Director, Transport Assessments Planning Services
Department of Planning, Industry and Environment
GPO Box 39
Sydney, NSW 2001

Application: SSI 7485

I write regarding the proposed modification to M4-M5 Link, Mod 2 The Crescent overpass and changes to pedestrian infrastructure in North Annandale, Rozelle and Rozelle Bay Foreshore area. *I object to the overpass and the relocation of the GreenLink and*

Figure 4-4 Elevation: Indicative view of The Crescent overpass

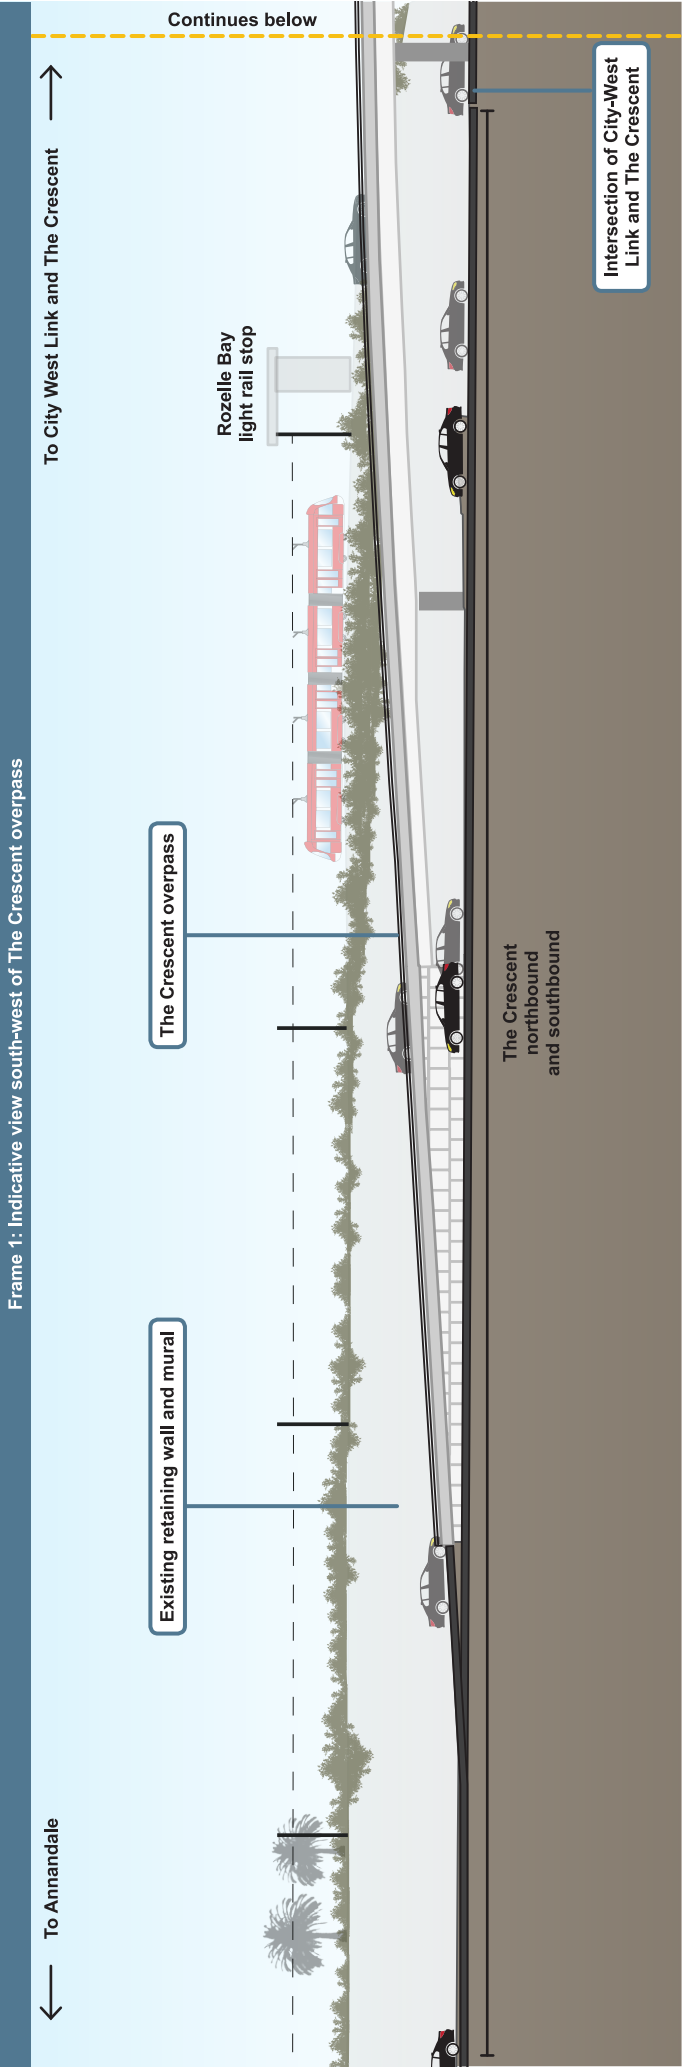
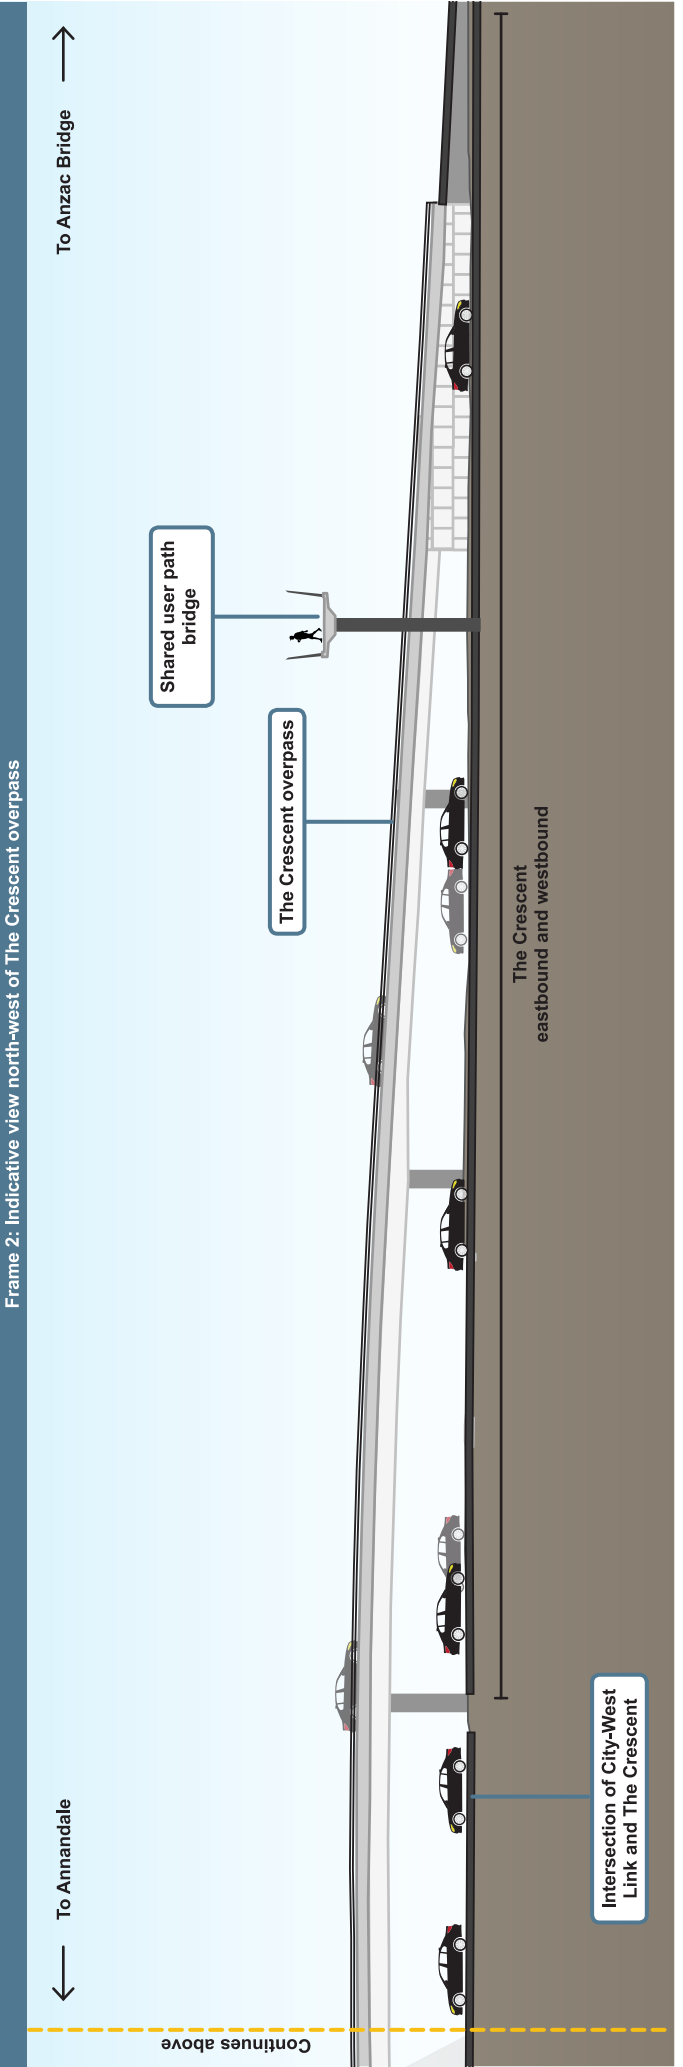
I request RMS work with the community to explore alternate design options to the proposed new car overpass design and the changed pedestrian and cyclist links. I am seeking the reinstatement of the safe, direct access from the approved EIS GreenLink to create a continuous green open space connection from the Rozelle Rail yards and Annandale to the foreshore. The GreenLink was more than just a walk way - it put people central to the design, maximising safety, and providing much needed accessible open space for the community now and into the future Bays Precinct design.

- The significantly reduced safety and increased risk for pedestrians and cyclists with removed access over The Crescent to Bicentennial Park and the increased traffic along Johnson Street.
- Being required to cross five sets of pedestrian lights at The Crescent as my option to reach the foreshore from Annandale or from Rozelle Bay light rail stop.
- Removal of direct active links to the foreshore, cutting the community off from the area and the proposed revitalisation of the entire Bays Precinct, including linking the Light Rail and Bus stops to a Ferry wharf and Metro station.
- Urban and landscape design that is being built before a finalised Masterplan for the area.
- Traffic changes that limit movements around the suburb and create further congestion in the local streets of Annandale, Forest Lodge, Glebe, Lilyfield and Rozelle with no planning to deal with these.

Figure 4-6 Elevation: Indicative view of Rozelle Rail Yards Pedestrian and Cycling Green Link

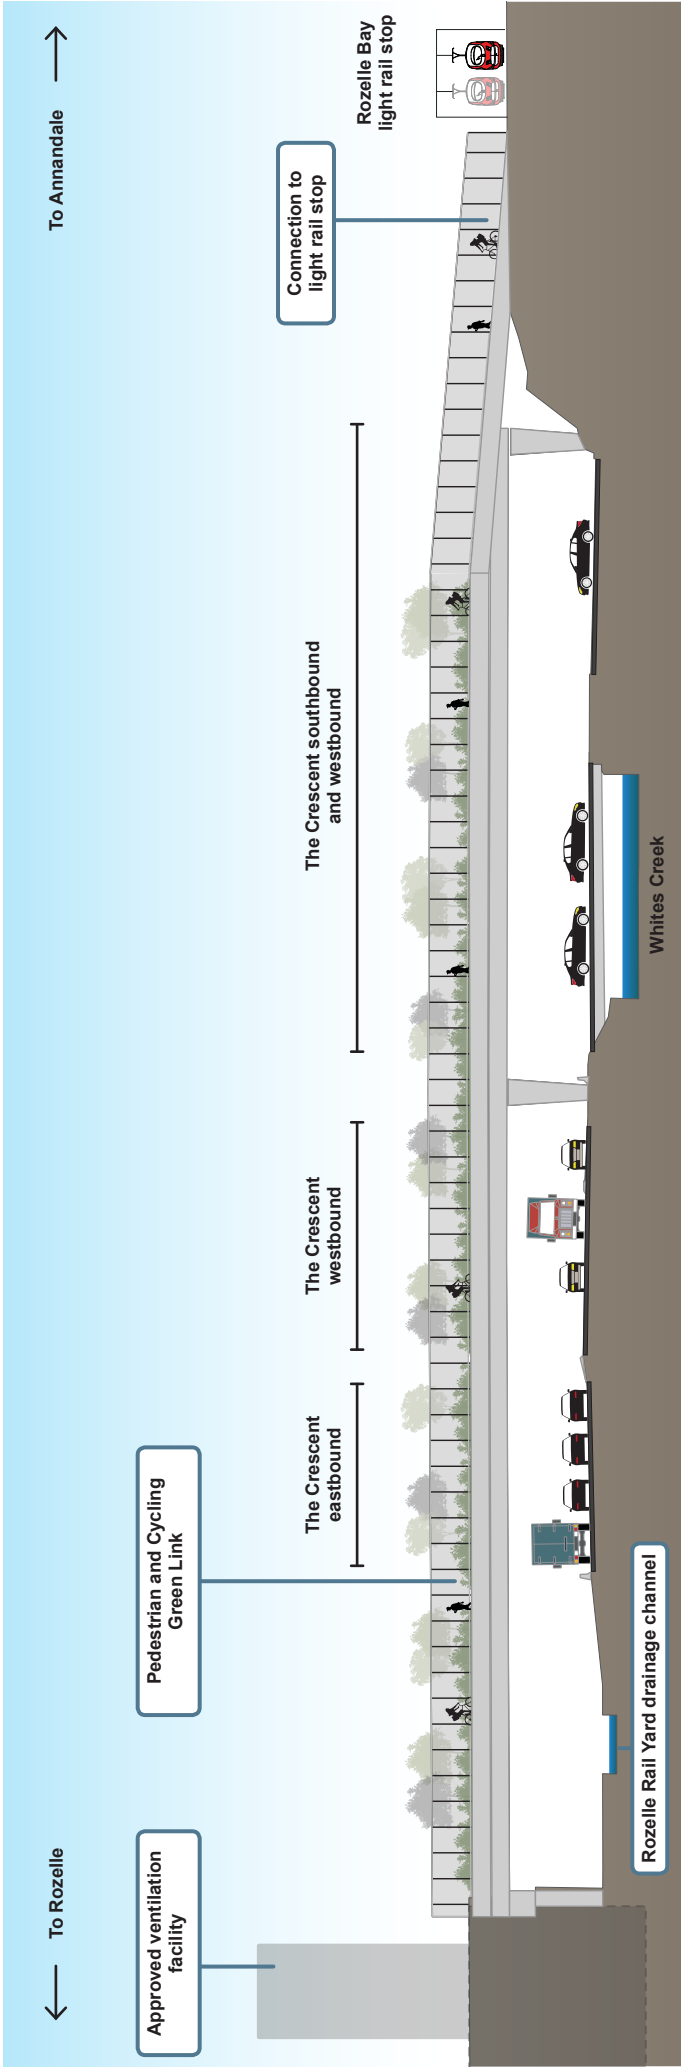
- Reinstate the GreenLink connecting communities and green open space from Rozelle to Bicentennial Park
- Relocate and design pedestrian and cyclist connections that are continuous, safe and direct.
- Design the modification infrastructure and active links in response to the character of the suburbs, the location of the foreshore and it's potential future development.
- Provide pedestrian and cyclist paths that maximise people safety and do not force them onto busier streets, unsafe concrete plazas and caged walkways.
- Integrate active and direct connections to all active transport – including the future Metro West and Foreshore Ferry Wharf
